Rezoning Transportation Analysis

Petition Number: 2020-013

Date	Description
02-24-20	First Review (EL)
08-19-20	Second Review (KP)
09-17-20	Third Review (KP)
10-16-20	Fourth Review (KP)

RZ-1

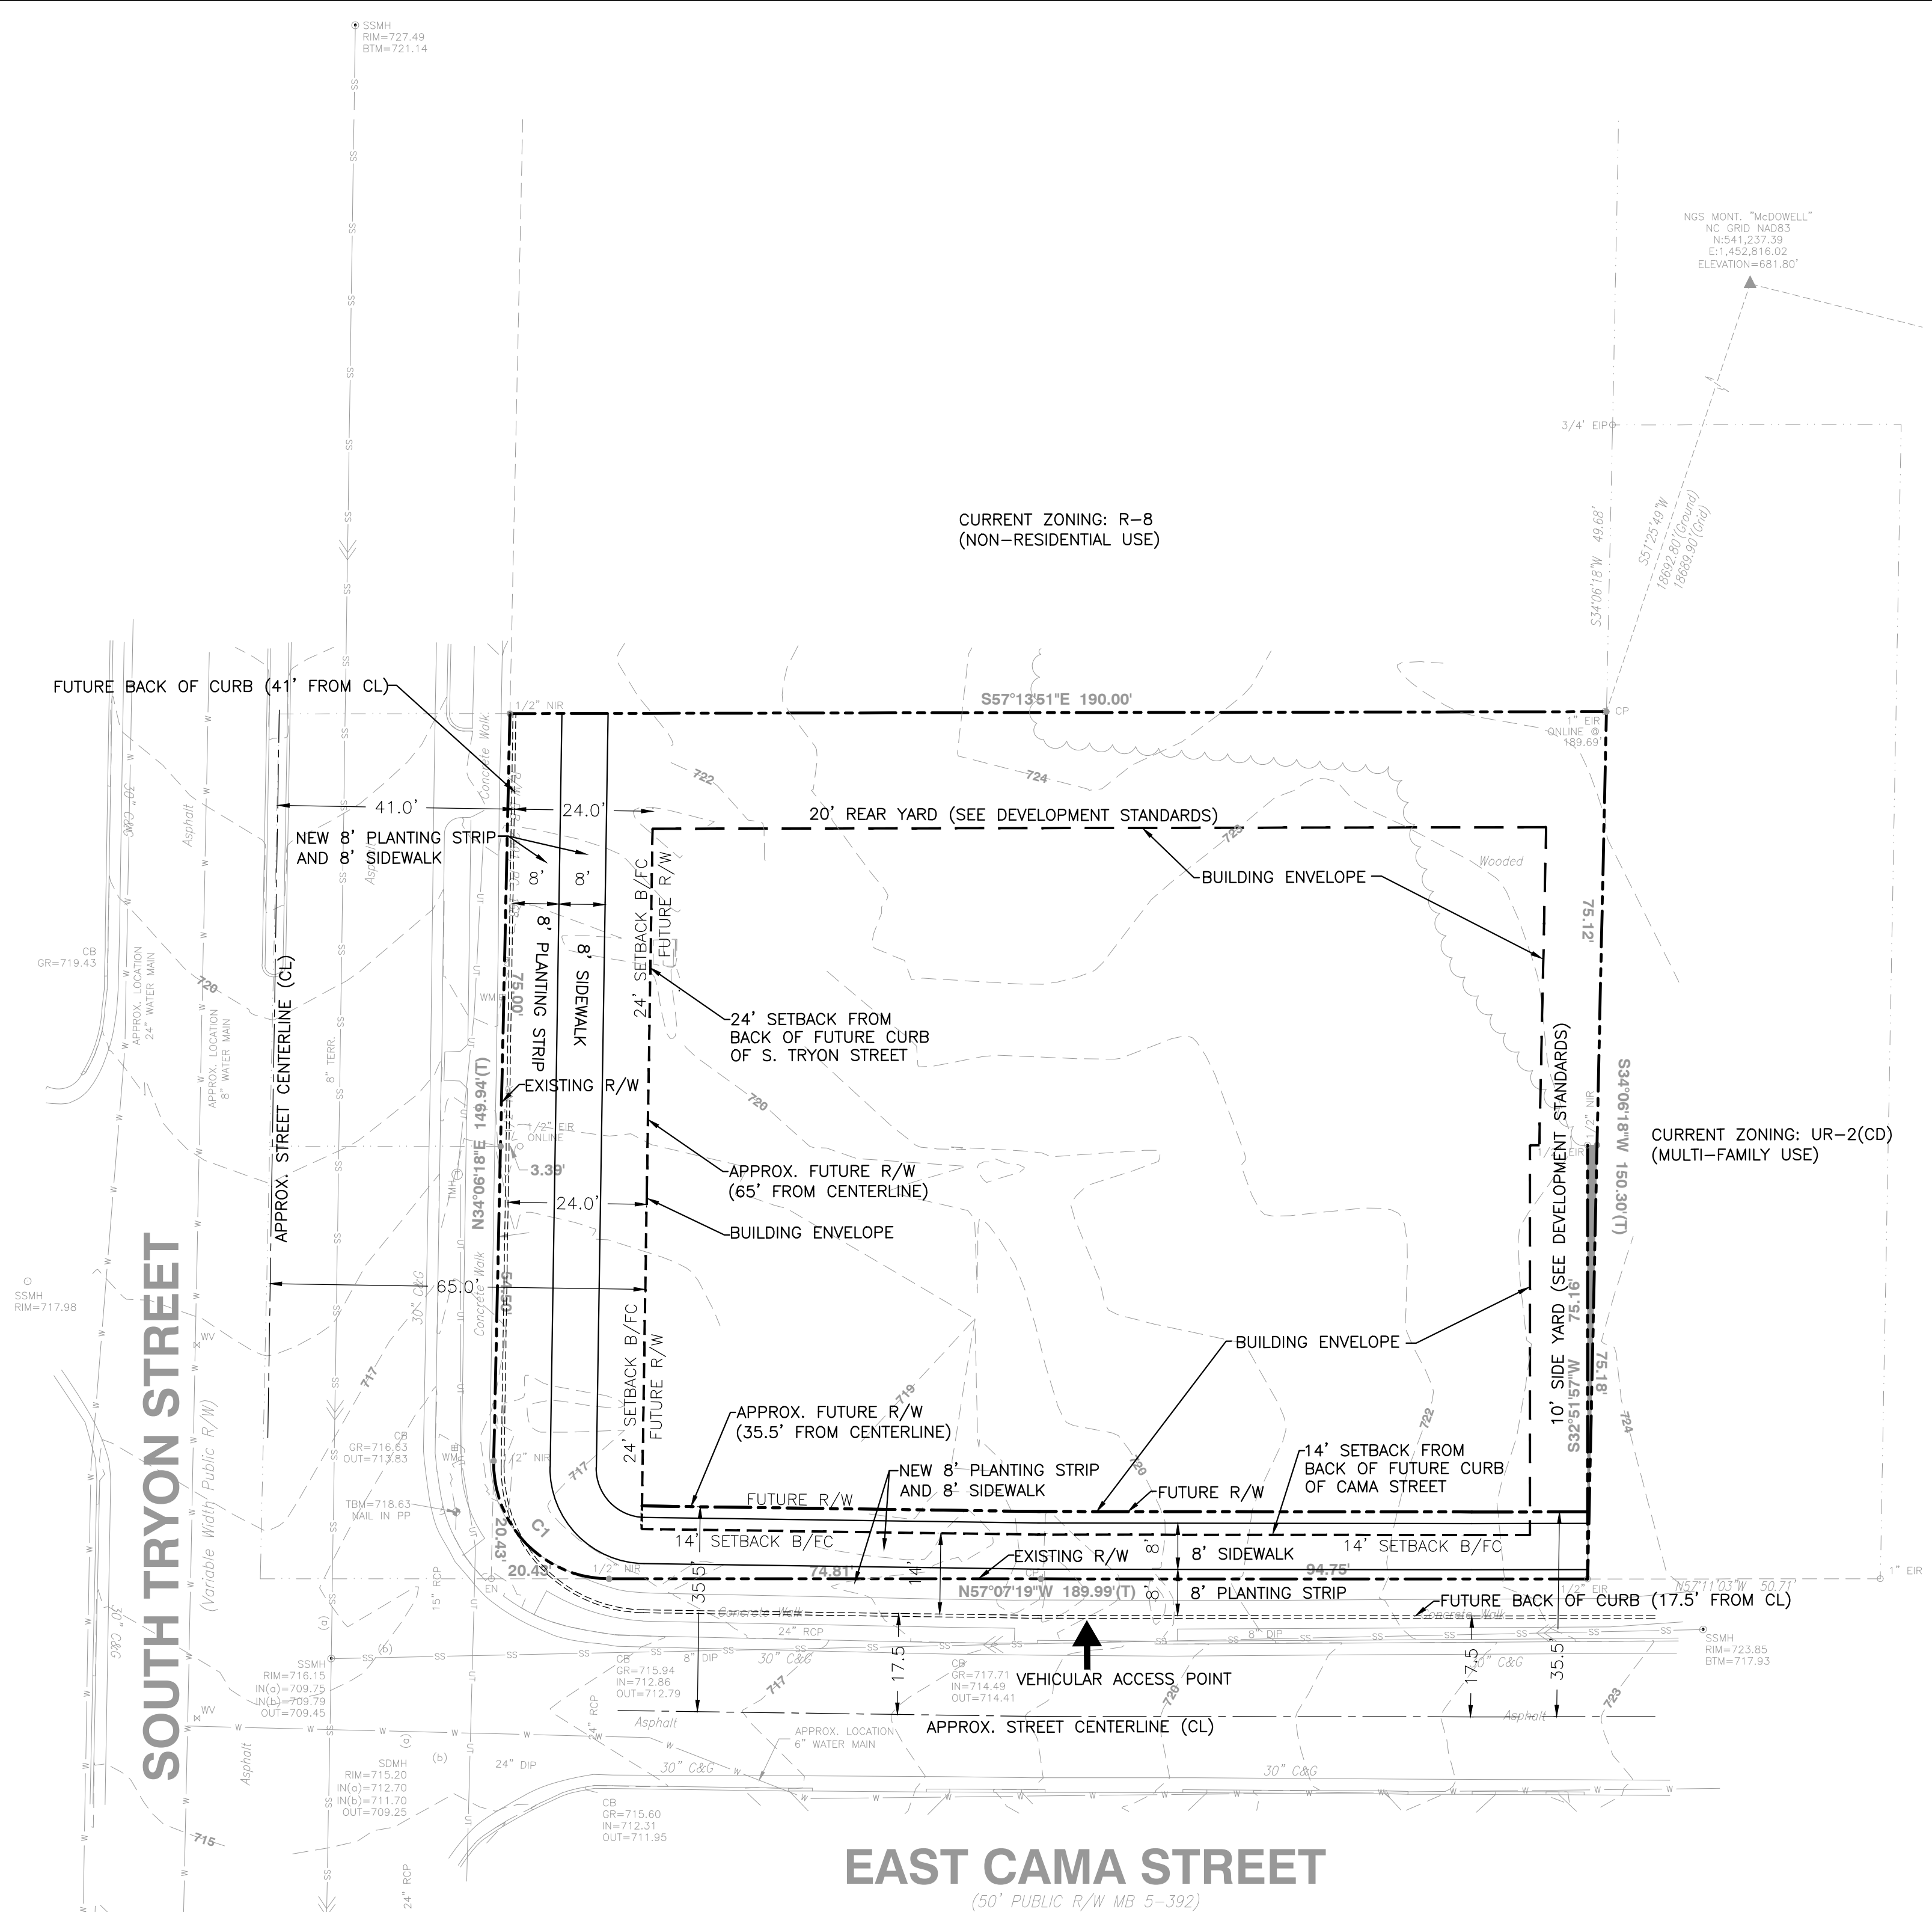
1. ~~**Curbline**~~ The proposed zoning district has a setback measured from back of the existing or proposed future curbline.
 - a. ~~**South Tryon Street:**~~ The future location of curb and gutter is 41 feet from road centerline, per the council adopted CDOT Streets Map.
 - b. **East Cama Street:** The future location of curb and gutter is 21.5 feet from road centerline, per the council adopted CDOT Streets Map. **New Comment from 10-12-20 Site Plan: 20.5-foot is shown, please show 21.5-feet.**

Label and dimension the curb and gutter from the centerline for each road.

5. Revise the site plan and conditional note(s) to commit to construct an 8-foot planting strip and 8-foot sidewalk, per the Scaleybark Transit Station Area Plan, with respect to the future curbline, along both South Tryon Street and East Cama Street. The Scaleybark Transit Station Area Plan remains as the reference for the streetscape requirements for this proposed rezoning.

Updated Comment: Will need to update future back of curb along Cama Street to approve this comment.

6. Revise the site plan and conditional note(s) to provide two curb ramps at the intersection of South Tryon Street & East Cama Street. **Updated Comment from 10-12-20 Site Plan:** Please show curb ramps on the site plan.

7. Revise the site plan and conditional note of Section (C.Transportation.1.) to provide one access off of East Cama Street, via a CLDSM standard detail 1025.E - Type II Modified Driveway. NCDOT will not permit access off South Tryon Street.
Updated Comment: Driveway type should be included in the site plan and conditional notes.

9. Revise the site plan to show/propose a location for trash receptacles/pick-up.
- ~~10. Revise the site plan to add a note specifying all transportation improvements will be approved and constructed before the site's first building certificate of occupancy is issued. The petitioner may phase transportation improvements if said improvements and phasing are explicitly described in site plan notes.~~
